**WRITTEN REPRESENTATIONS OF THE HISTORIC BUILDINGS AND MONUMENTS  
COMMISSION FOR ENGLAND (HISTORIC ENGLAND)**

**FOR AN ORDER GRANTING DEVELOPMENT CONSENT FOR THE: BOTLEY WEST  
SOLAR FARM**

**APPLICATION REF: EN010147**

**DEADLINE 2 SUBMISSION: 4<sup>TH</sup> JUNE 2025**

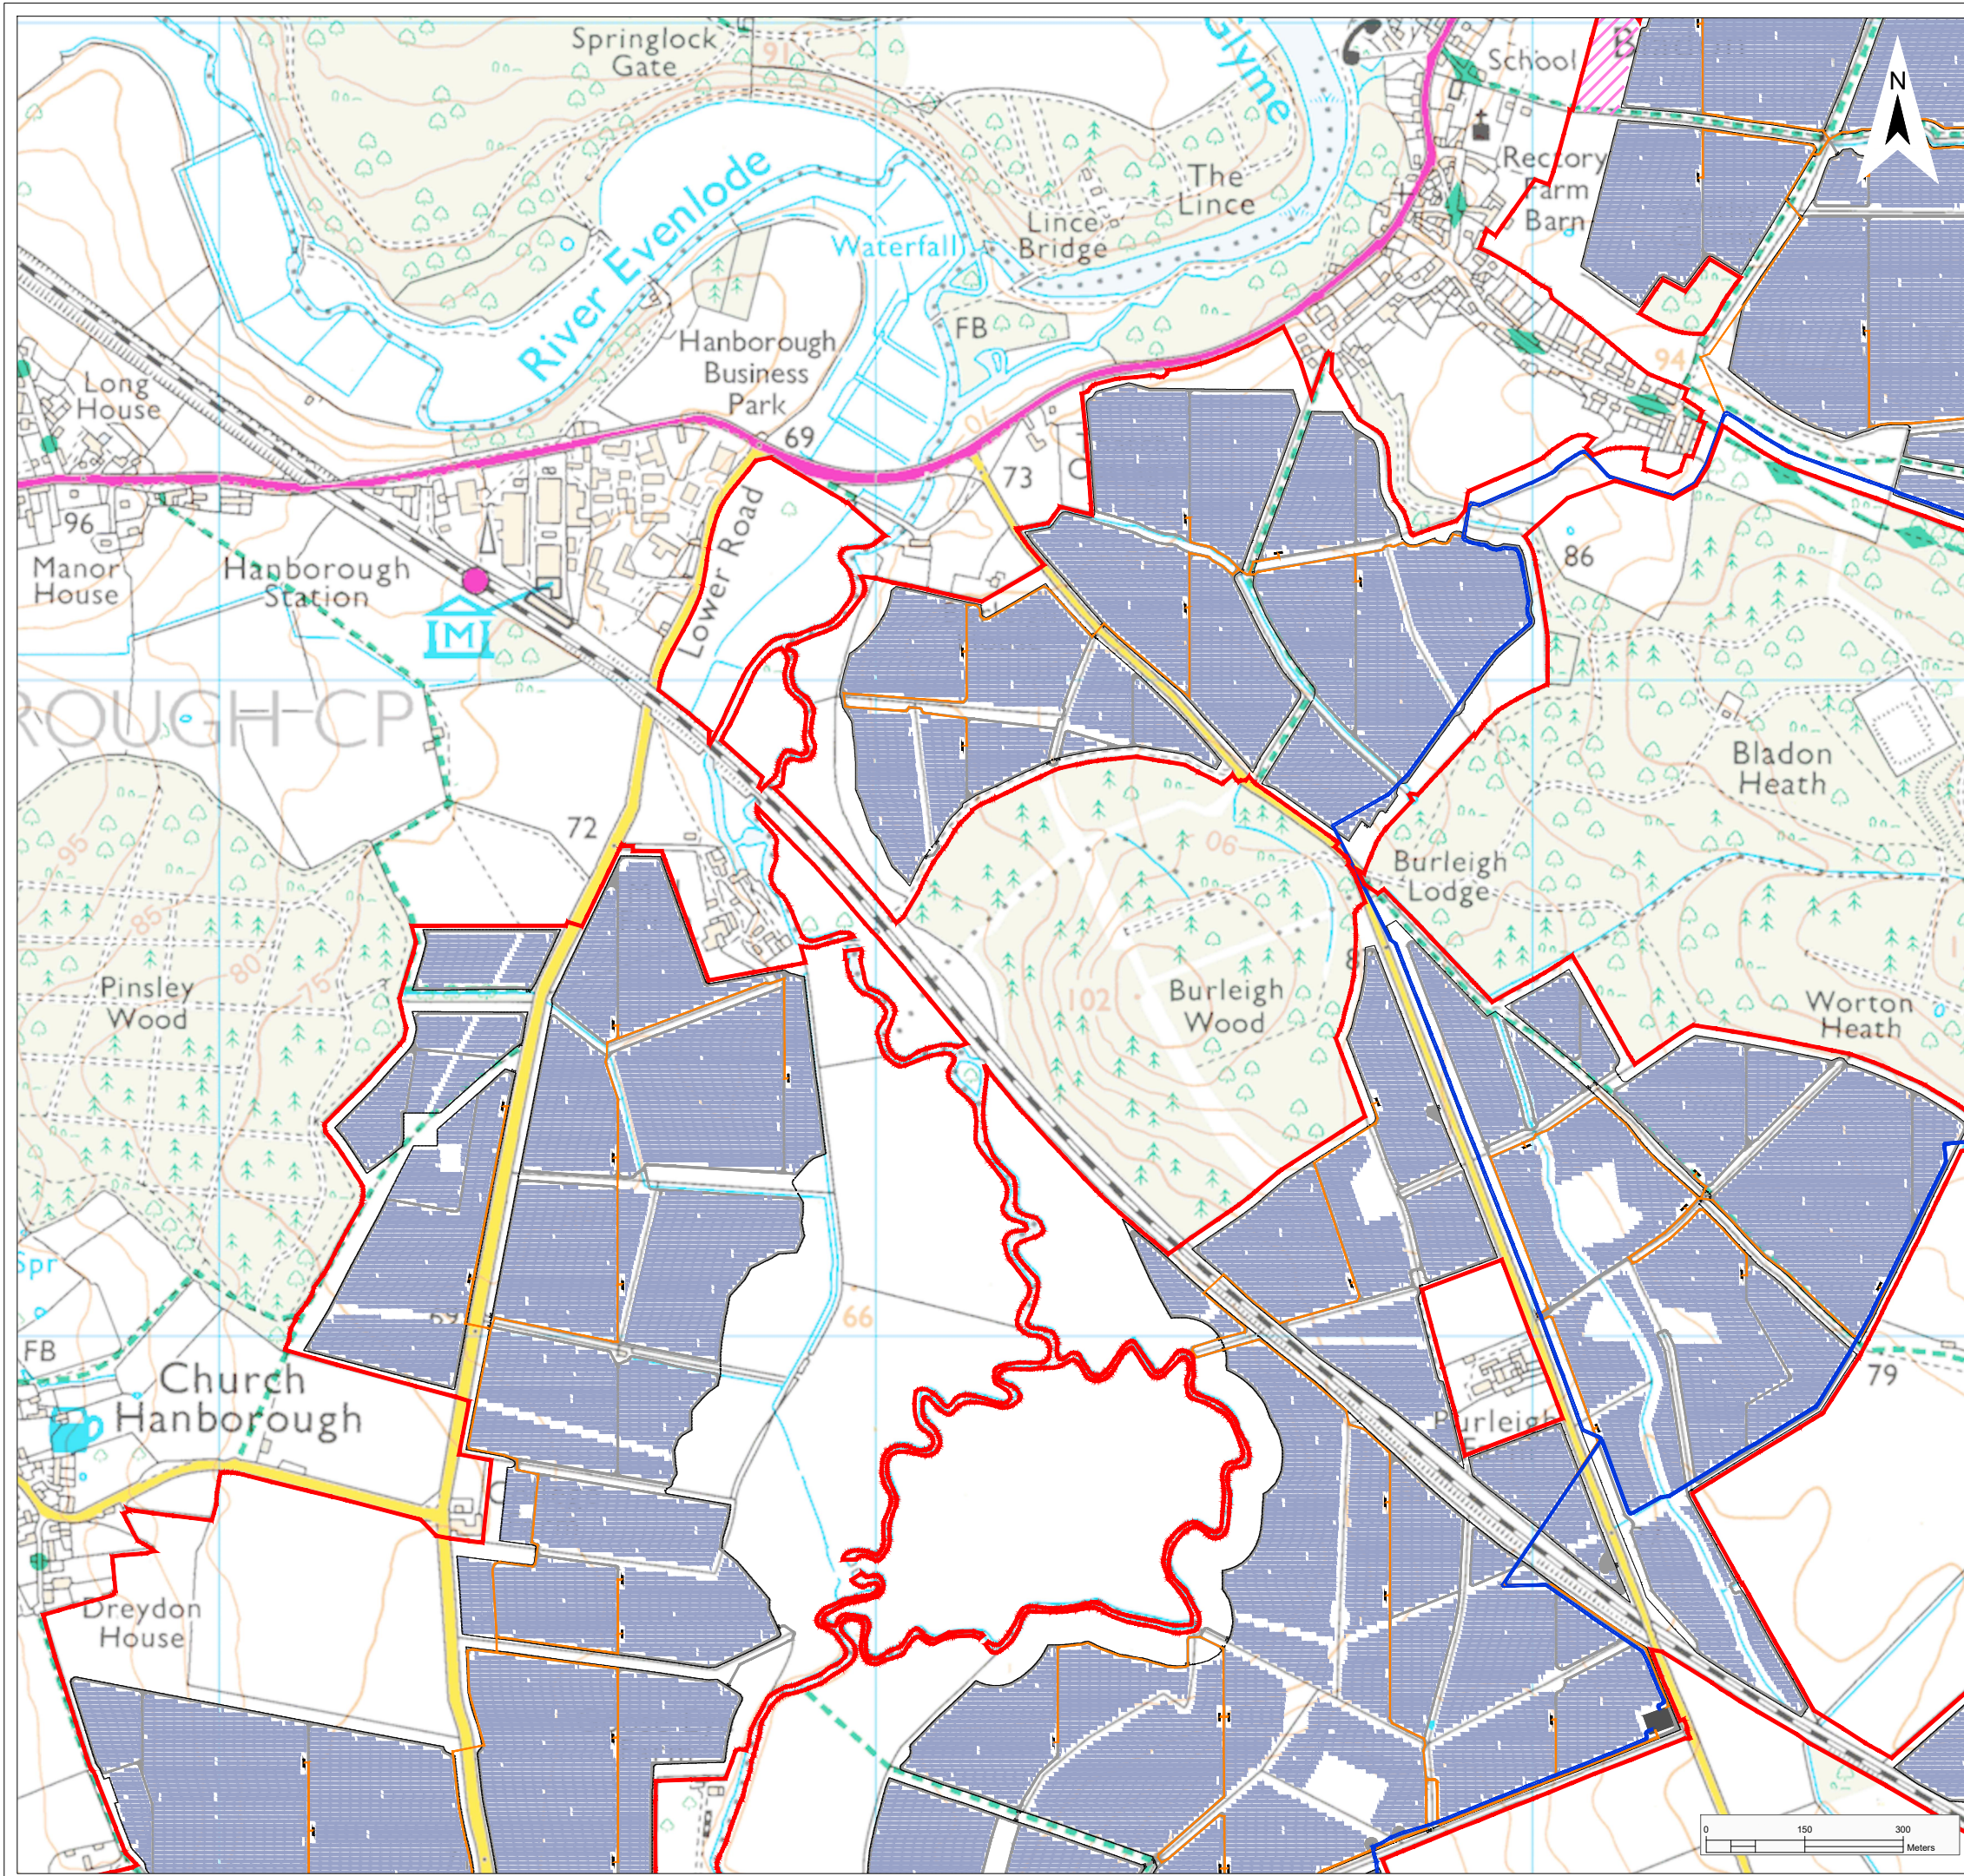
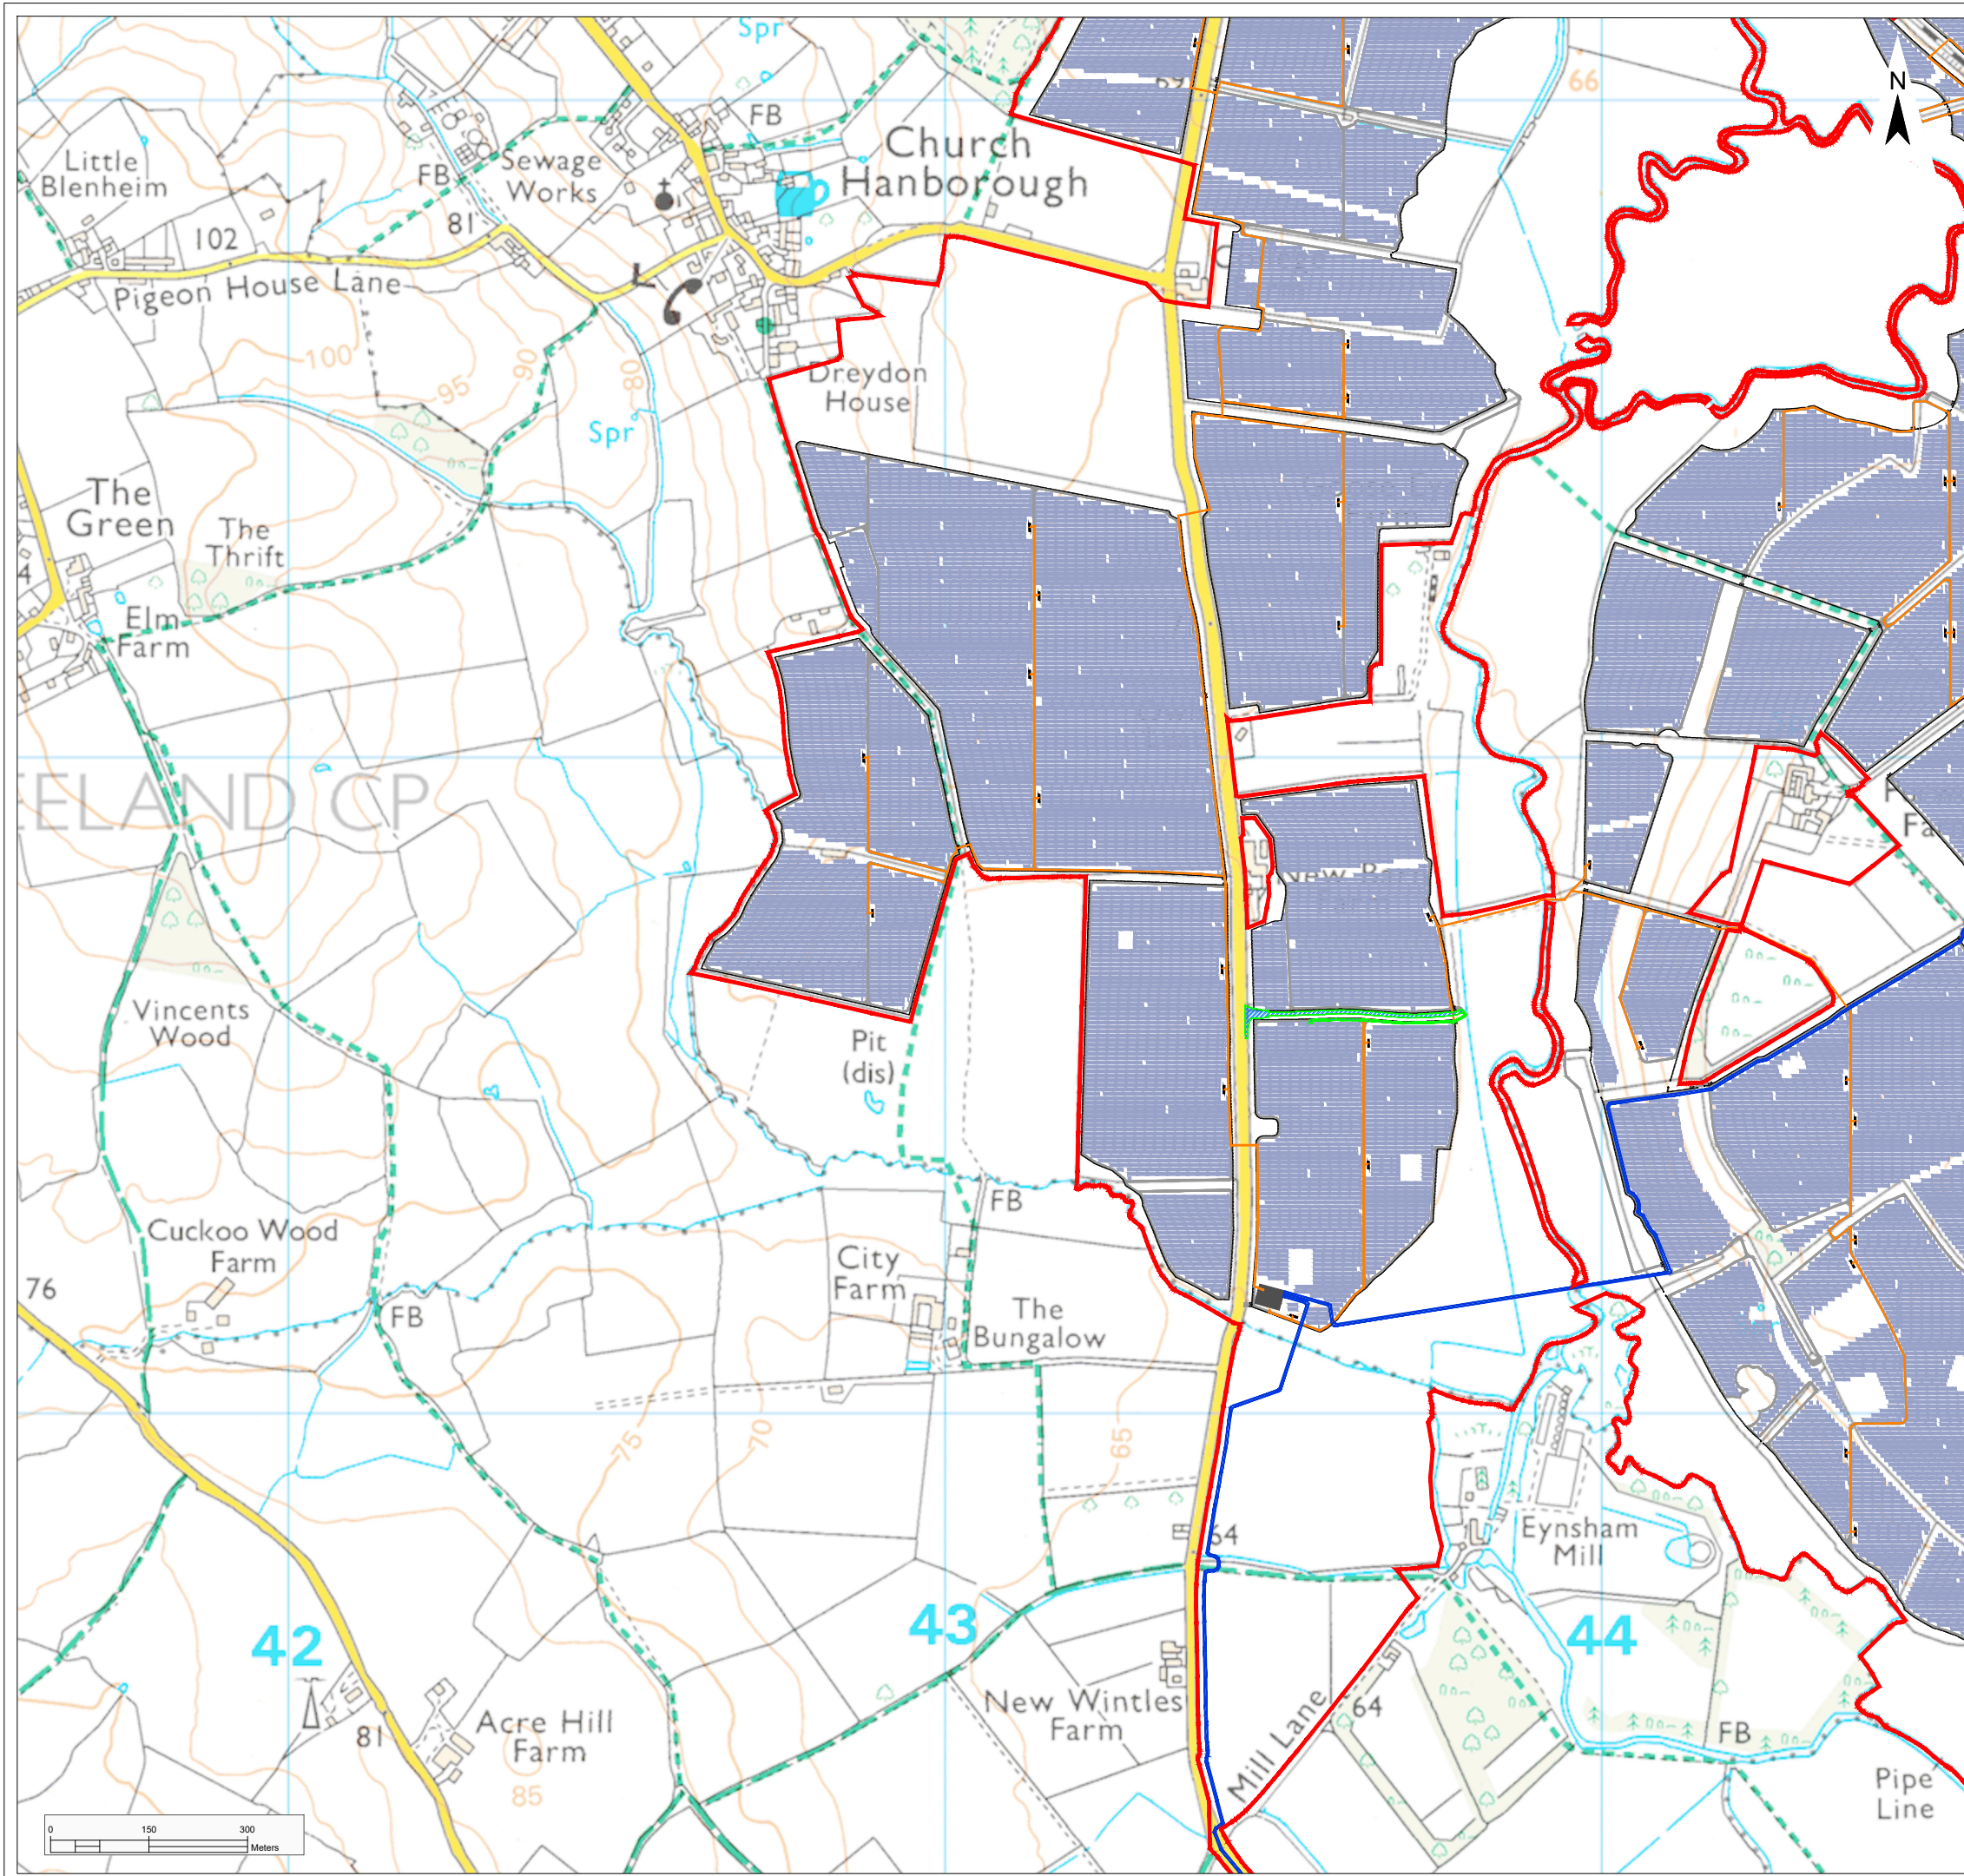
- 3.4. Historic England has made its own assessment of the contribution the application site makes to the significance and OUV of Blenheim Palace World Heritage Site (WHS). On this basis we have identified areas where we consider panels would cause harm to this internationally recognised and important site and should be removed to avoid harmful impacts.
-

3.5. We considered that whilst the majority of the scheme would not harm the OUV of the WHS, land parcels 2.1, 2.2, 2.5 and 2.20-2.26 of the central section of the Botley West Solar Farm would do so. This is because these land parcels do contribute to the maintenance of Blenheim's OUV as these fields are locations in which the Blenheim ensemble can be appreciated from open countryside. Solar array development in these fields would therefore detract from the contribution made by the setting of Blenheim, in a way that would harm its Outstanding Universal Value. We therefore recommended the removal of panels from these parcels.
